TOWN AND COUNTRY PLANNING ACT 1990 FULL

Reference:	H16-0887-25	Date of Decision:	13th November 2025
Applicant:	Mr & Mrs D Scase 20 Cley Hall Drive Spalding PE11 2EB		
Location:	20 Cley Hall Drive Spalding		
Description:	Proposed Domestic Garage

Drawing.
FLOOR PLAN - SECTION - ELEVATIONS

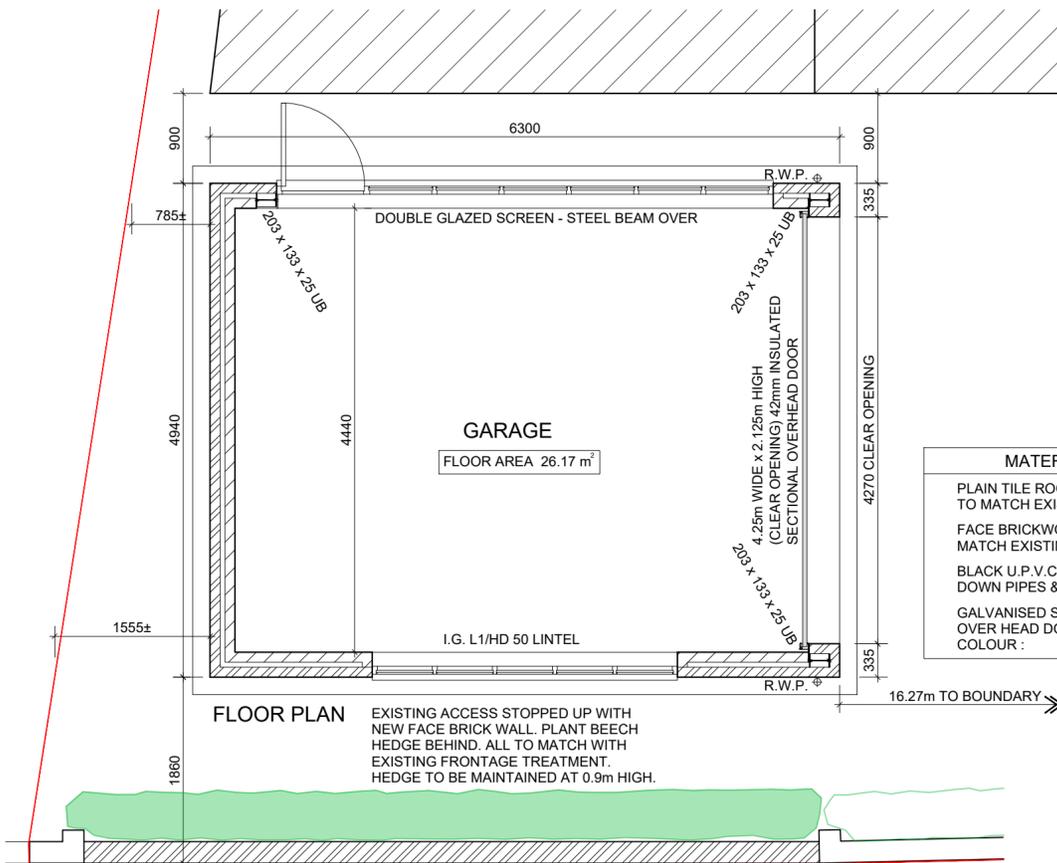
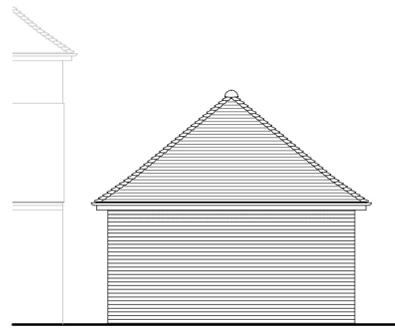
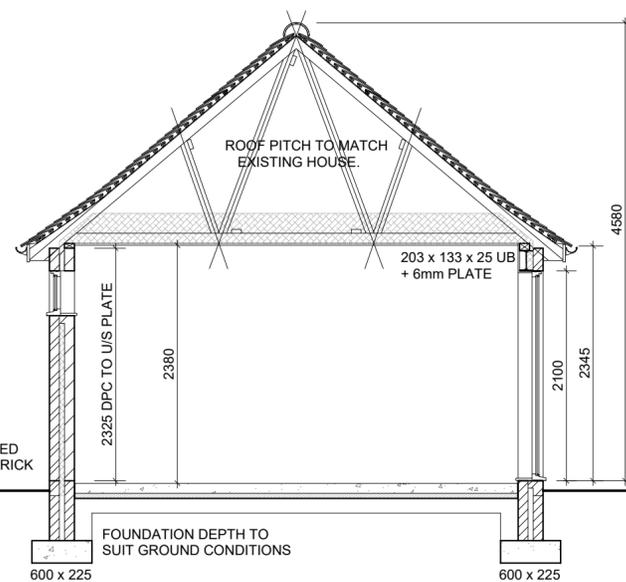
- 1 It is considered that the proposed garage would constitute an incongruous and harmful form of development, significantly at odds with the established built form of the area. Within the Cley Hall Drive area, no comparable forms of development exist, resulting in this garage appearing as a visual anomaly. The harmful impacts created by this are exacerbated by the significant scale of the garage and its positioning, which results in an unduly dominant development.

The proposal is therefore considered to be contrary to Policies 2 and 3 of the South East Lincolnshire Local Plan, 2019, in design terms, as well as Section 12 of the National Planning Policy Framework, December 2024 and the provisions of the National Design Guide.
